6/27/06

## Evergreen Park Plat P-06-13 Comments

The Evergreen Park Plat application for 14-lot Performance Based Cluster Plat pursuant to Kittitas County Code 16.09 on 45 acres of R-3 zoned land should be denied or remanded back to CDS for the following reasons:

GeoDatum Inc.
SURVEY-CIVIL-STRUCTURAL
22525 SE 64th Pl #266
Issaquah, WA 98027
(425) 837-8083
PROJECT#: SHEET: 2
2005-045 OF: 3

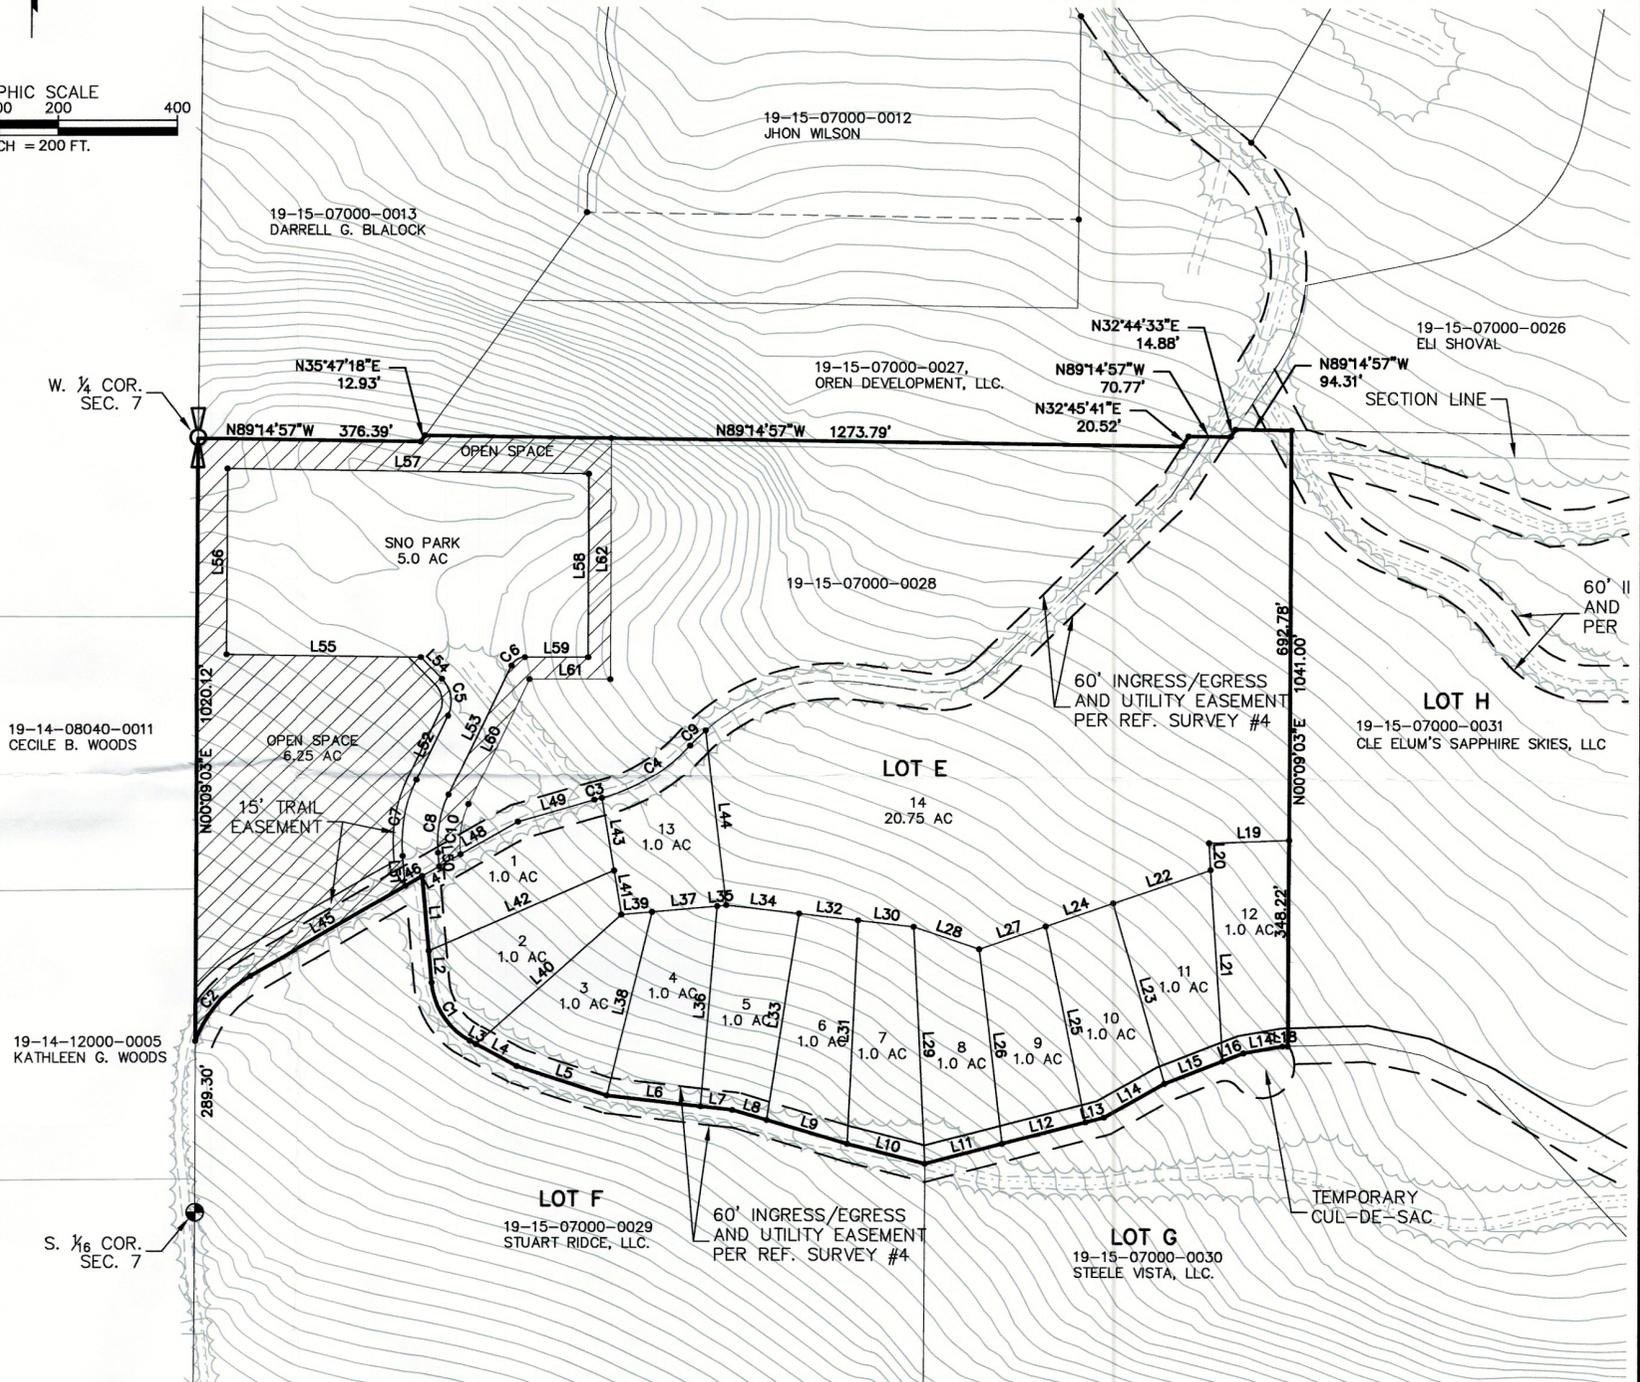
- The 11.25 acres identified as open space is also suspect in its conformance to Code 16.09. The roadway accessing the "sno-park" and other roadways can not be included into the open space total because Code 16.09.100 open space definition excludes roadway surfaces from open space designation. The buffer area around the sno park includes the required set back from adjacent property owners should not be included as open space as it is required by code as building set back specifically not allowed in the performance based cluster code.

- The applicant is not providing access to USFS lands since the property does not border USFS lands. Any future connectivity to USFS trail systems need to be spelled out now as to how this will occur before points on the public benefit rating system are allotted. Easements to USFS lands through neighboring properties is lacking so the public benefit of connectivity is suspect. The upper county parks district has indicated there is an intent to deed the sno-park to their organization; where is this information is the plat application. Is this true, does the public have assurance of use of the sno-park in return for public benefit points?
